Our Ref: PREAPP/23/00863

PROPOSAL: Proposed erection of a rear extension for form new kitchen, family room, downstairs disabled access toilet and utility room with upper floor new bedroom with attached shower room and new family bathroom

LOCATION: 38 Belle Vue Road, Shrewsbury, Shropshire, SY3 7LL.

OUTCOME: Amendments needed.

PROPOSED ELEVATIONS

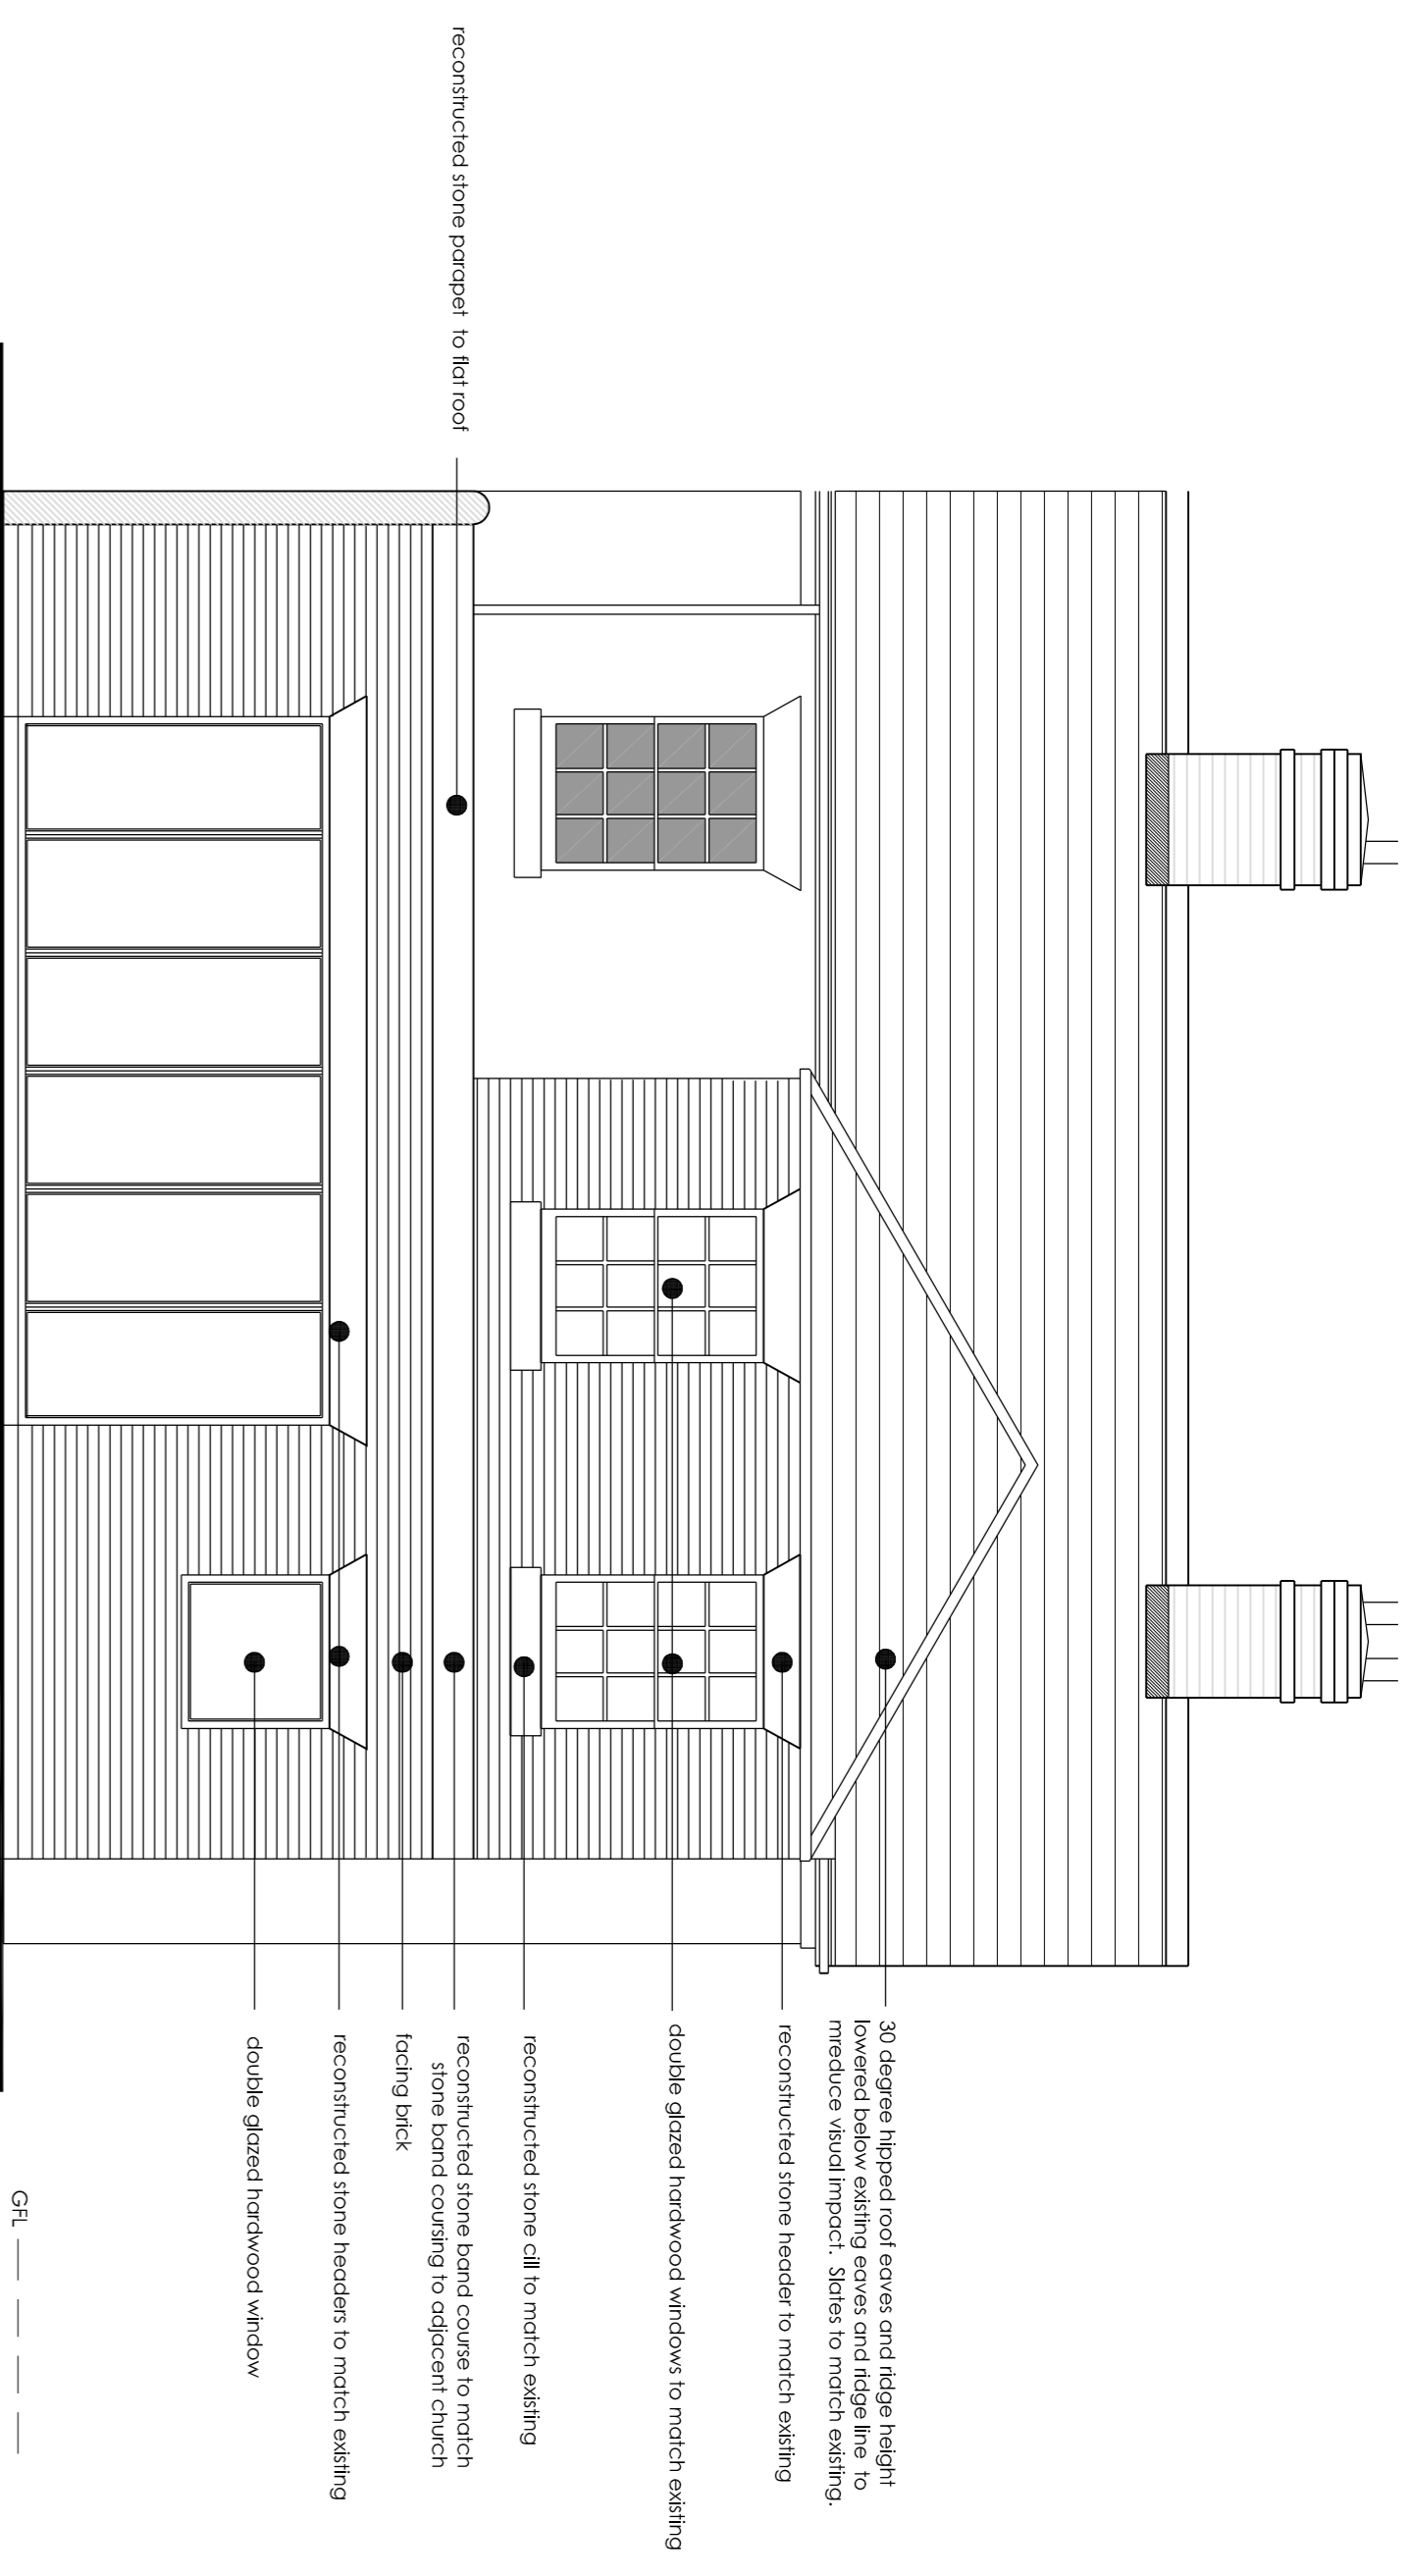
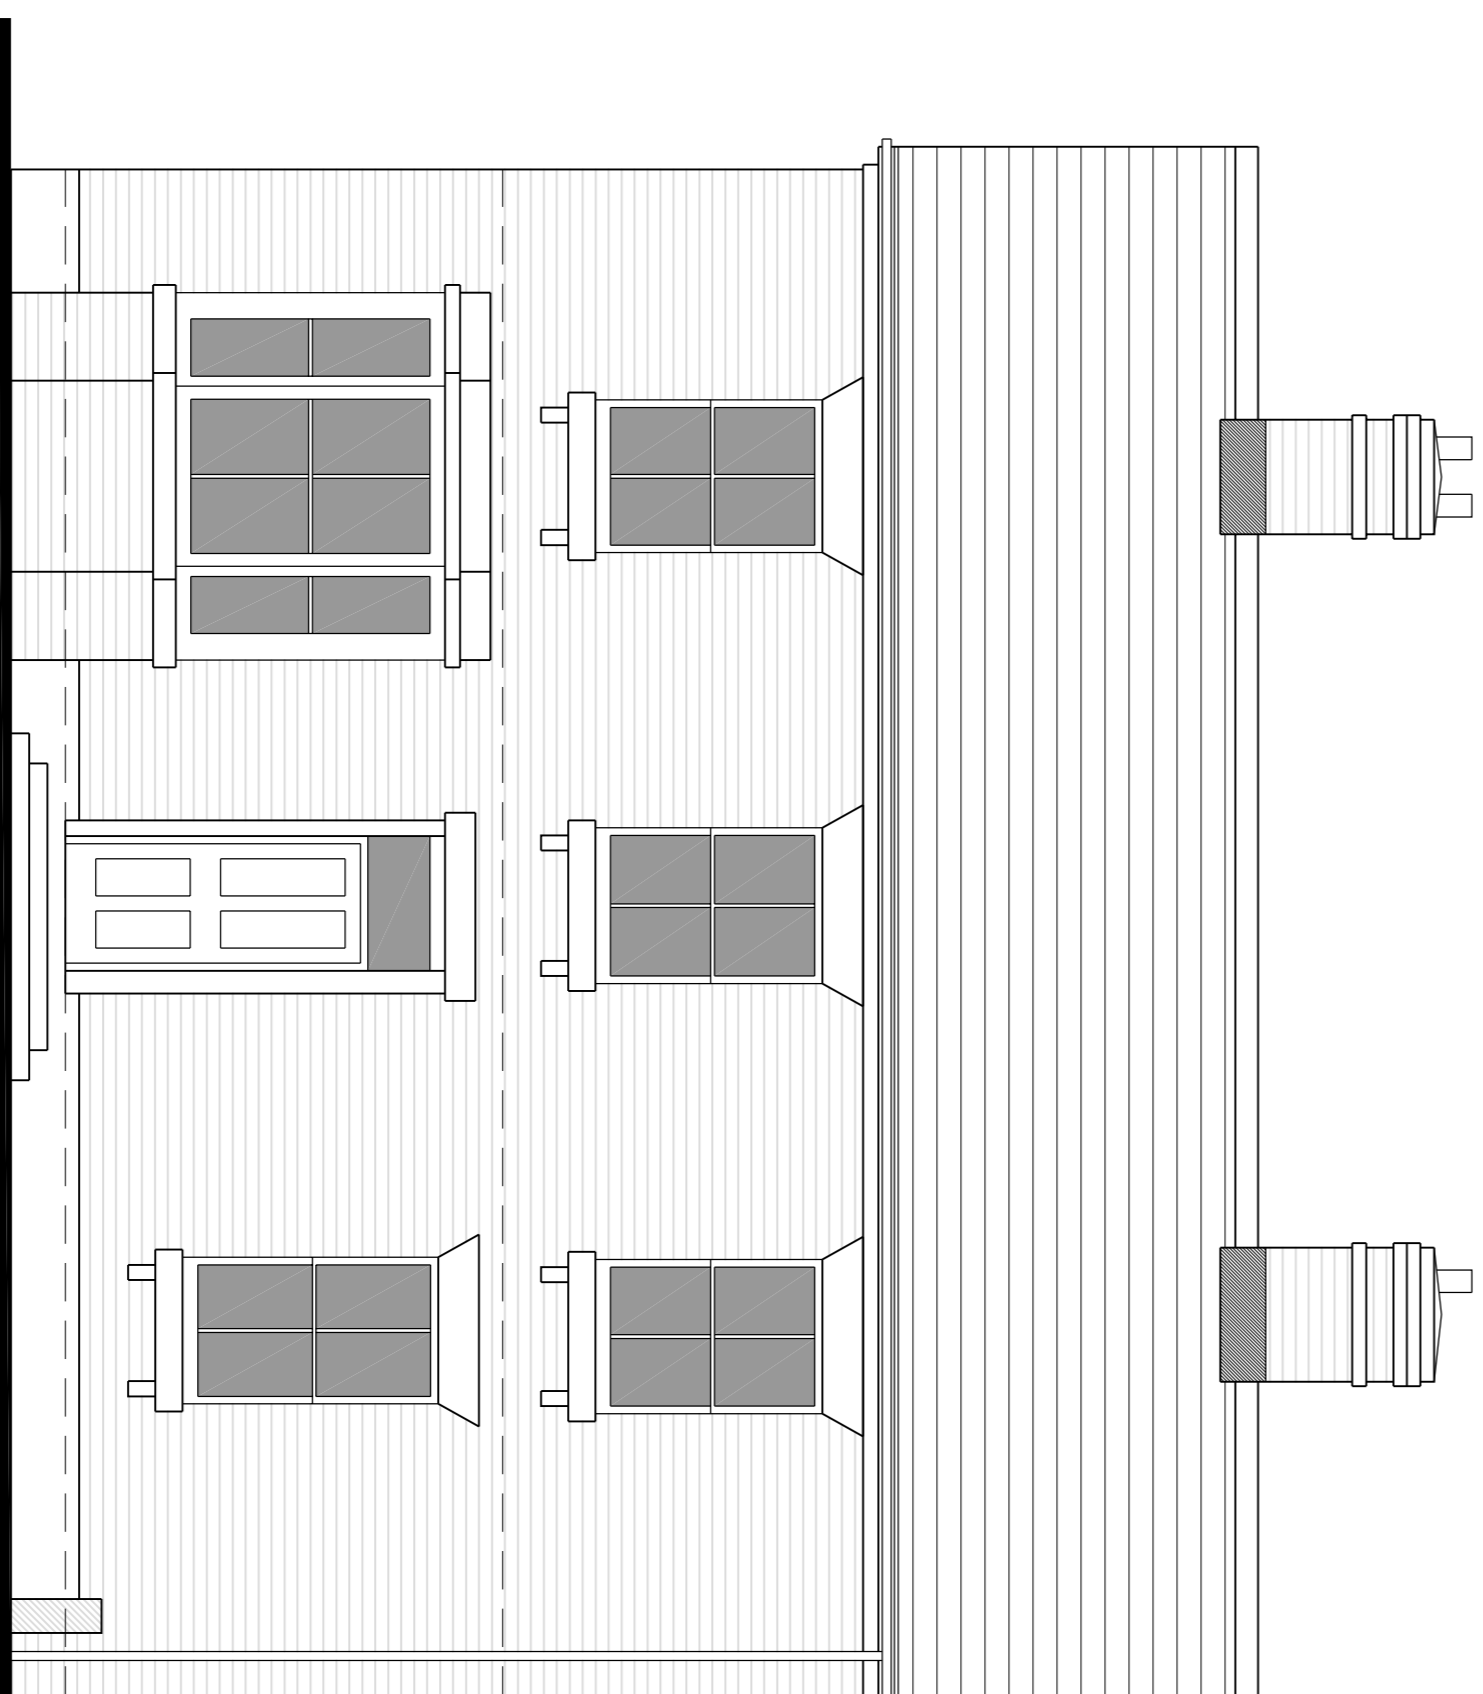
The principle of erecting two and single storey extensions to the rear of this dwelling is acceptable. However, I refer you to the comments below submitted by conservation team who recommend a reduced ridge height and inclusion of visual interest to the side elevation. On submission of a formal application, you will need to include a brief heritage impact assessment and in order to avoid conditions on the decision notice it would be beneficial to include details of external materials, joinery, windows and doors.

Generally, in this more traditional form and materiality we would not raise a heritage objection subject to agreeing final material samples. We do note that the side elevation facing the Church is quite tall as is the ridge height, and the side elevation wall a substantial area of unembellished brick, where dominant building forms should be avoided.
